Consultee comments

Reference:	SDNP/24/00924/TPO
Address:	1 Opie Gardens Farnham Road Liss Hampshire GU33 6JQ
Proposal:	T1 - Red Oak, Rear of property, Reduce height and spread by a maximum of 3 metres, remove deadwood and broken branches. To reduce risk of branch/stem failure and improve light to property.
Case Officer:	Adele Poulton

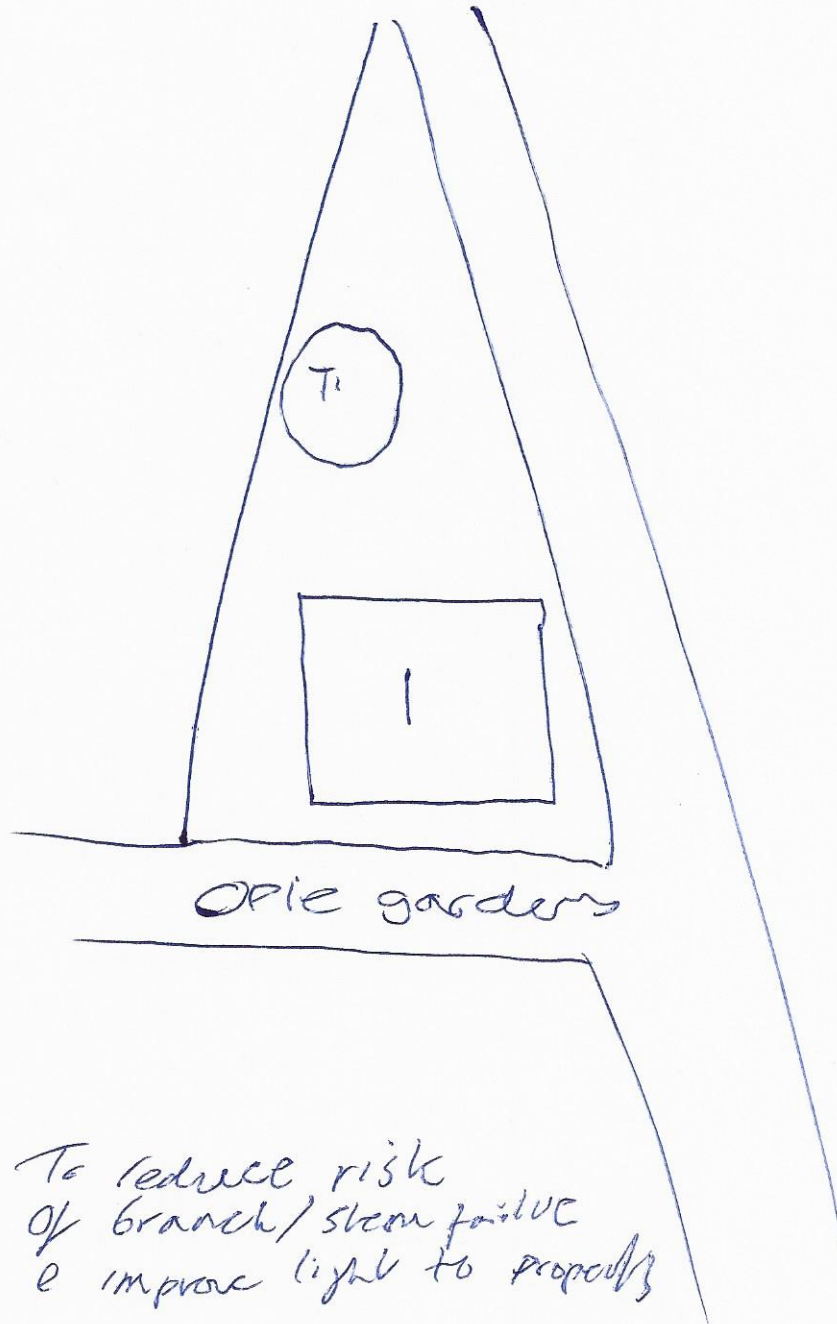
Comments:	<p>The original planning application comment from the EHDC arboricultural officer raised this as a possibility, hence the TPO, and the site layout was changed to ameliorate.</p> <p>It is to the north of the property so the light impact should be limited. I think the quality of the sketch makes it difficult to comment properly. The arboricultural officer should review.</p>
-----------	--
